From: Liz Annalls [REDACTED]
Sent: 12 August 2020 09:31
To: Planning.Responses <Planning.Responses@arun.gov.uk>
Subject: RE: Planning Consultation on: BN/57/19/RES

Application No: BN/57/19/RES
Site Address: Land East of Fontwell Avenue Fontwell Avenue Fontwell BN18 0SB
Description of Works: Approval of reserved matters for 3785sqm of light industrial floorspace (Class B1 (b)/(c)) following the grant of WA/22/15/OUT.

Client Rural Associates Project Title and Location GTR Factory Arundel Road, Fontwell, West Sussex	Drawing Title Detailed Planting Plan Ornamental Planting
Scale 1:100@A1	Drawn EZ
Approved DW	Date 30.01.20
Drawing No LLD1773-LAN-DWG-201	Revision 02

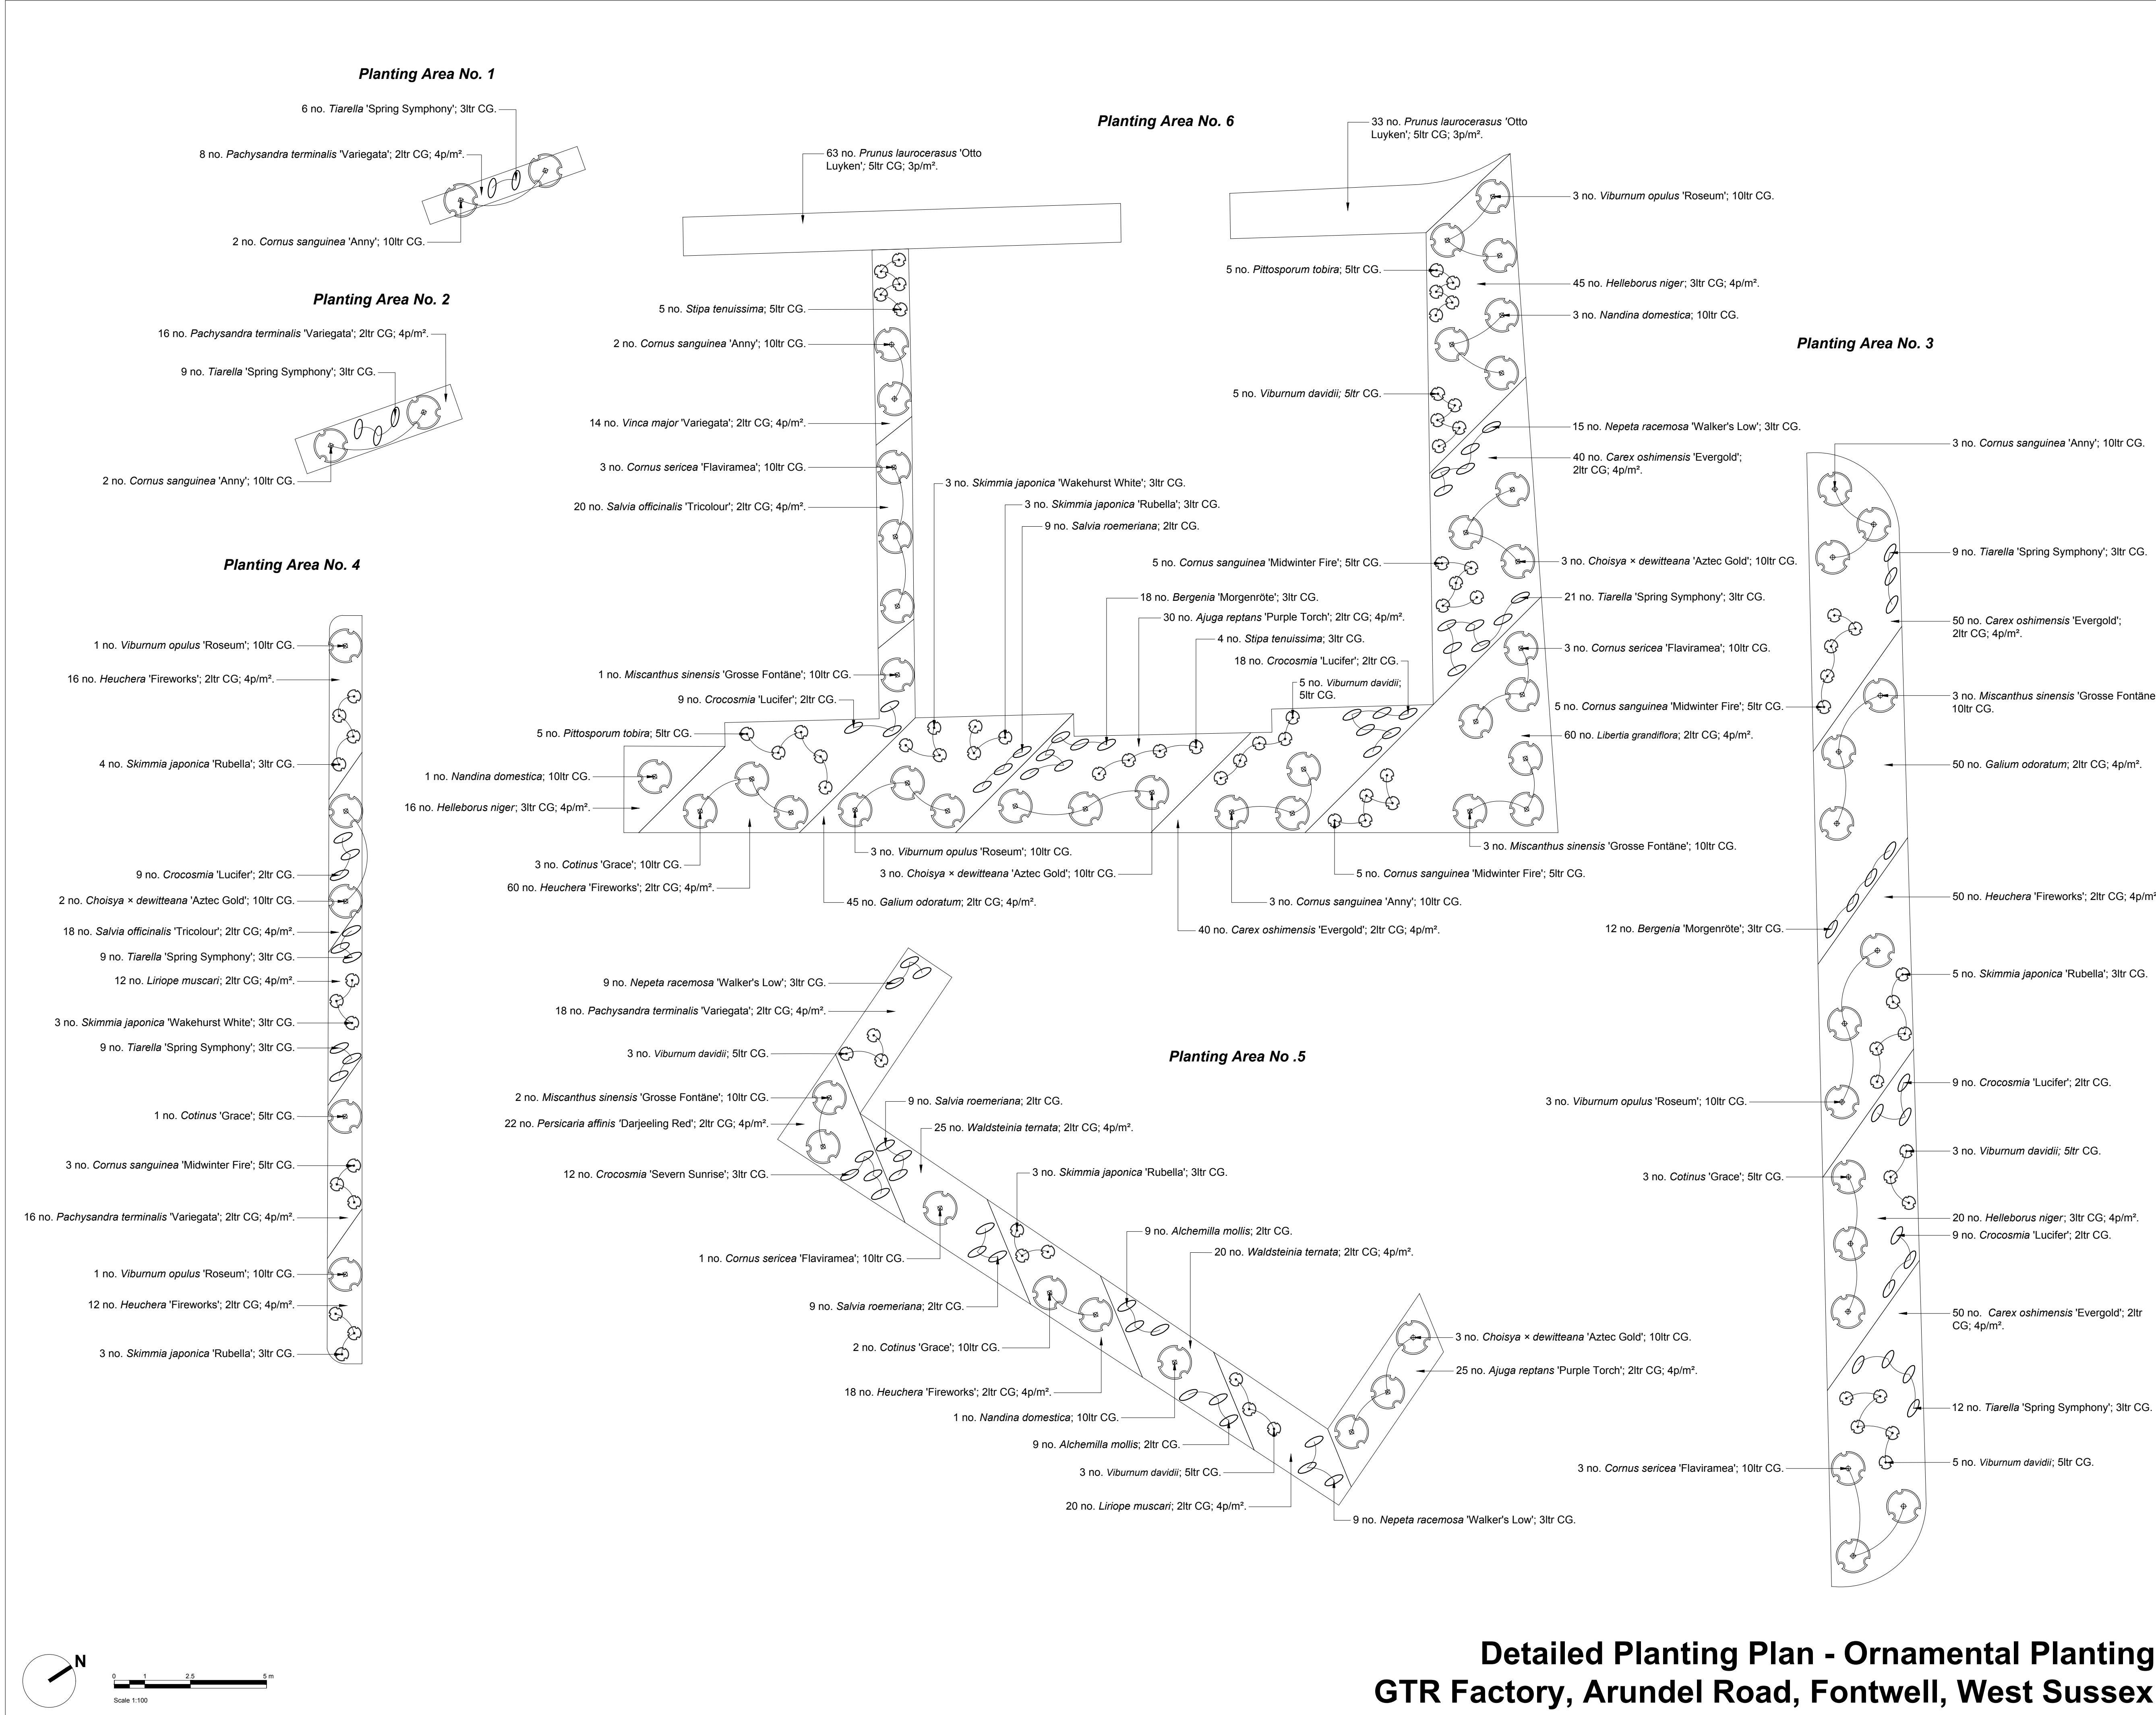
We are satisfied that the information submitted in relation to landscaping included within the Landscaping Management Plans (Feb 2020) is suitable.
